**Rezoning Transportation Analysis**  
**Petition Number: Insert Zoning Petition #2021-226**  
*General Location Identifier: 02902129, 02902130*

Revision Log:	Date	Description
	02-24-22	First Review (PDM)

The petition is located south of Galloway Road, City-maintained minor collector and west of Claybrooke Drive, a State-maintained local road. The petition is located in the Northeast Wedge outside Route 4. A Traffic Impact Study (TIS) is not needed for this site. Site plan revisions are needed to meet Chapter 20 ordinance requirements and/or the outstanding items including, but not limited to providing a 12-foot multi-use path connecting Arbor Vista Drive to the proposed public street, providing an 8-foot sidewalk and 8-foot planting strip, and labeling and dimensioning the right-of-way on Galloway Road. Further details are listed below.

**REZONING PLAN**

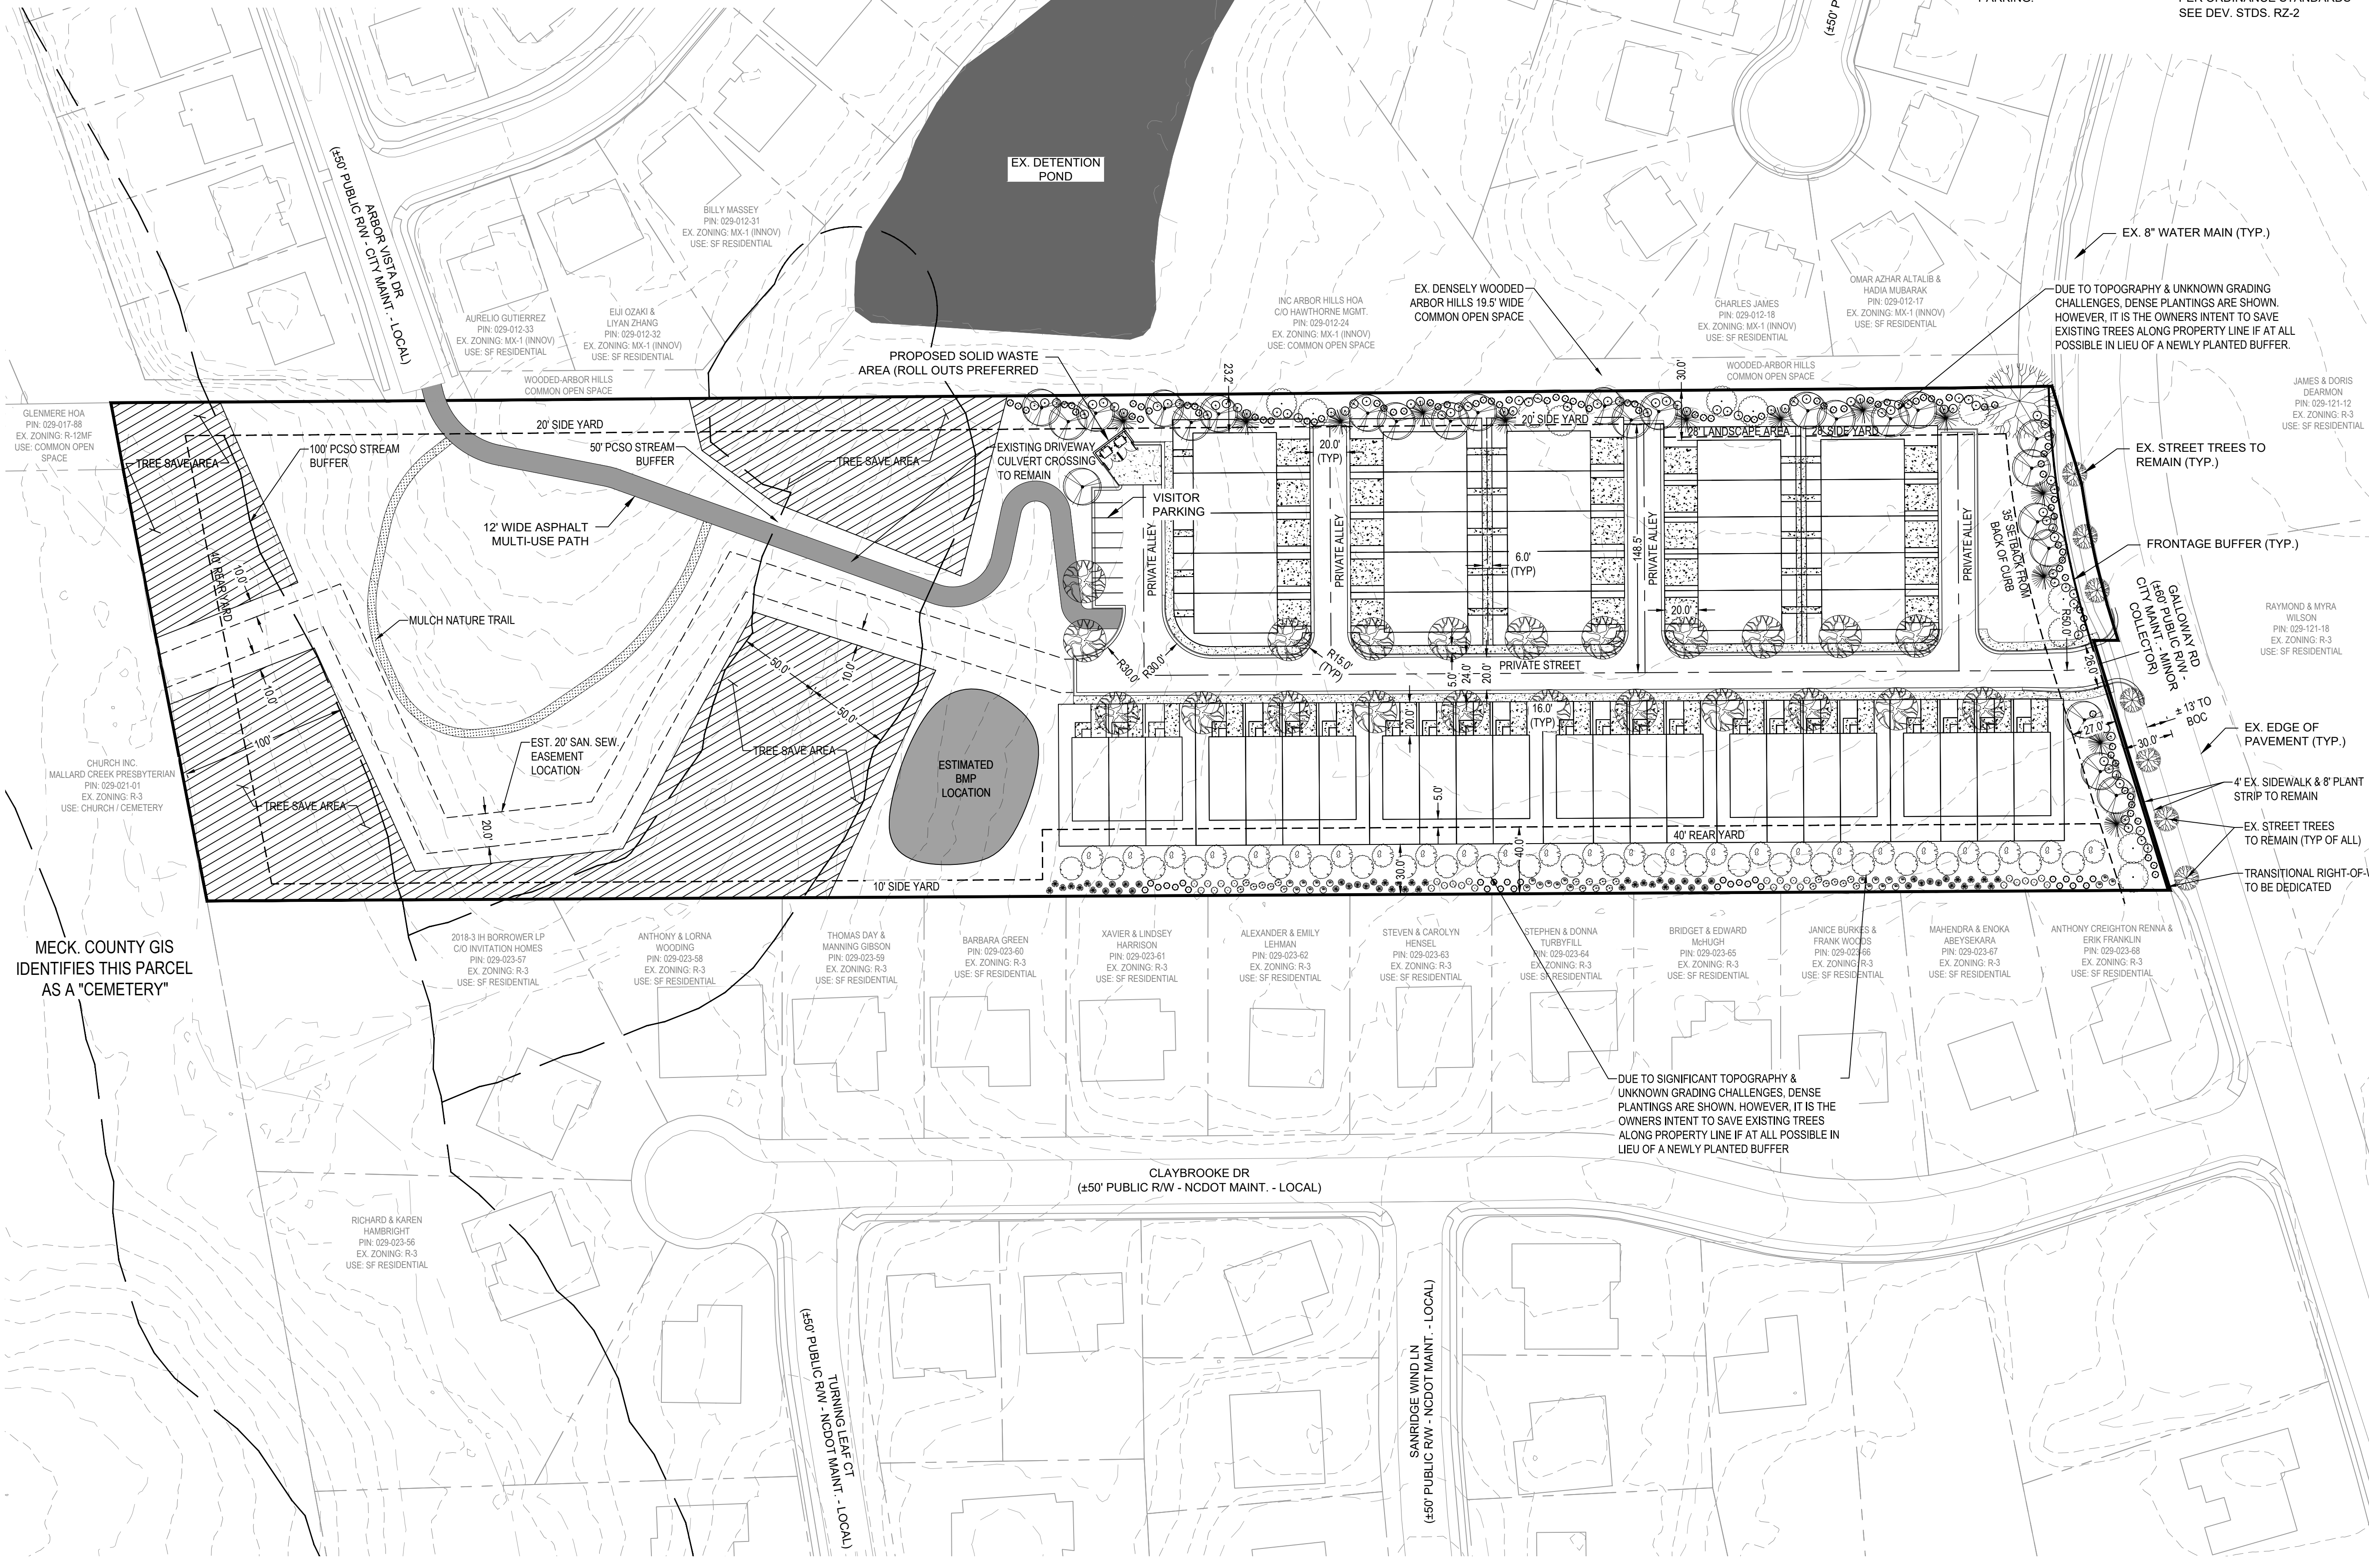
- Revise site plan and conditional note(s) to commit to dedicate 30-feet of right-of-way from the road centerline of Galloway Road. The site plan shall label and dimension the right-of-way from the road centerline. Callout the proposed right-of-way line as "Proposed ROW."

- Revise site plan to show the proposed 8-foot sidewalk and 8-foot planting strip located along Galloway Road per the conditional note 4.B.
  - The petitioner will construct an eight (8) foot planting strip and an eight (8) foot sidewalk along Galloway Road as generally depicted on the Rezoning plan.

- Revise the site plan to clarify if the existing building onsite will be removed or reused.

7. Revise site plan to provide curb ramps for the sidewalk along Galloway Road crossing the proposed private street.

8. Revise site plan to show the entire section of Galloway Road existing curb and gutter along the property frontage. Label and dimension the curb and gutter front the centerline of the road.
